3 August 2010

File No: W10/418

Request for Provision of Details of Key Issues and Assessment Requirements – Major Project Application MP10_0104 Public Domain Upgrade Works, The Rocks

Project: PLAN
SHOWING DETAILS & LEVELS OVER
FIRST FLEET PARK, CIRCULAR QUAY
SYDNEY

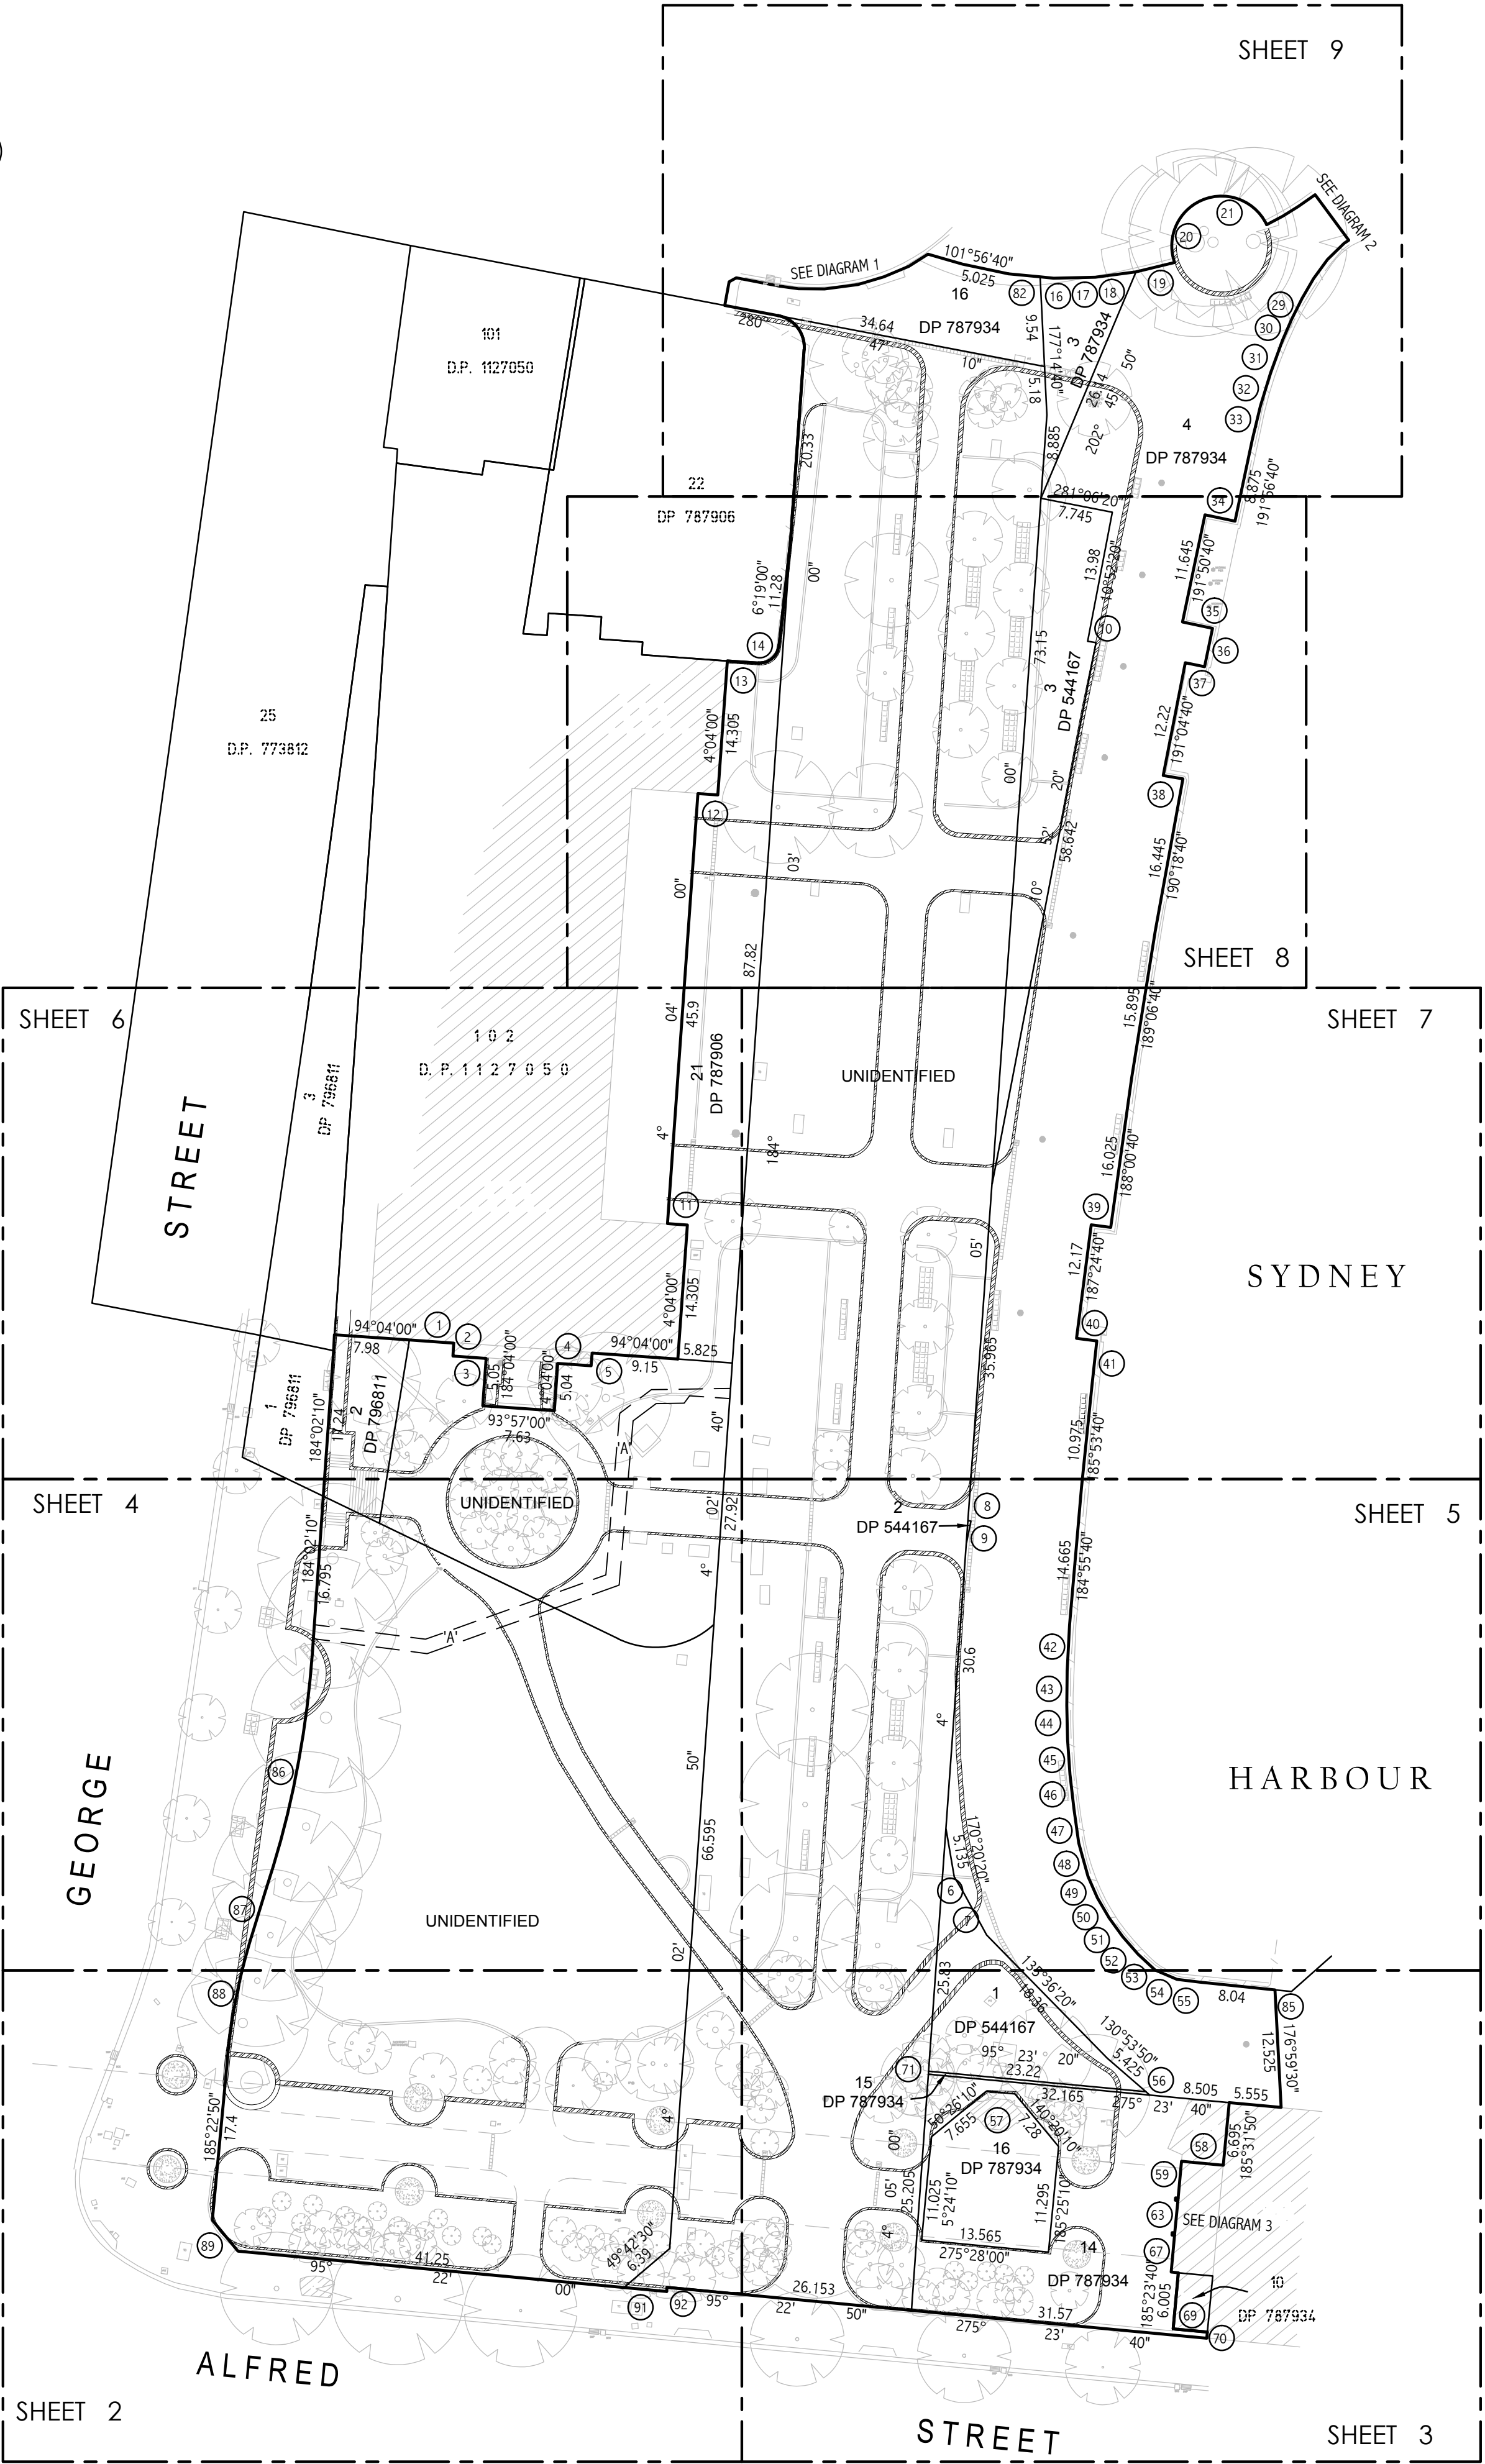
3. Real Property issues relation to the western promenade. While it is true the pavement area is SHFA property, at no point in the document does it acknowledge that this area is on top of NSW property and that NSW have plans to return this area to its original alignment as shown on the attached plan. The promenade is in fact a walkway on top of a NSW wharf. The wharf requires continuous maintenance and the substructure is beyond its useful economic life. The West Circular Quay proposal should therefore address this issue in regard to NSW Maritime plans for its land.
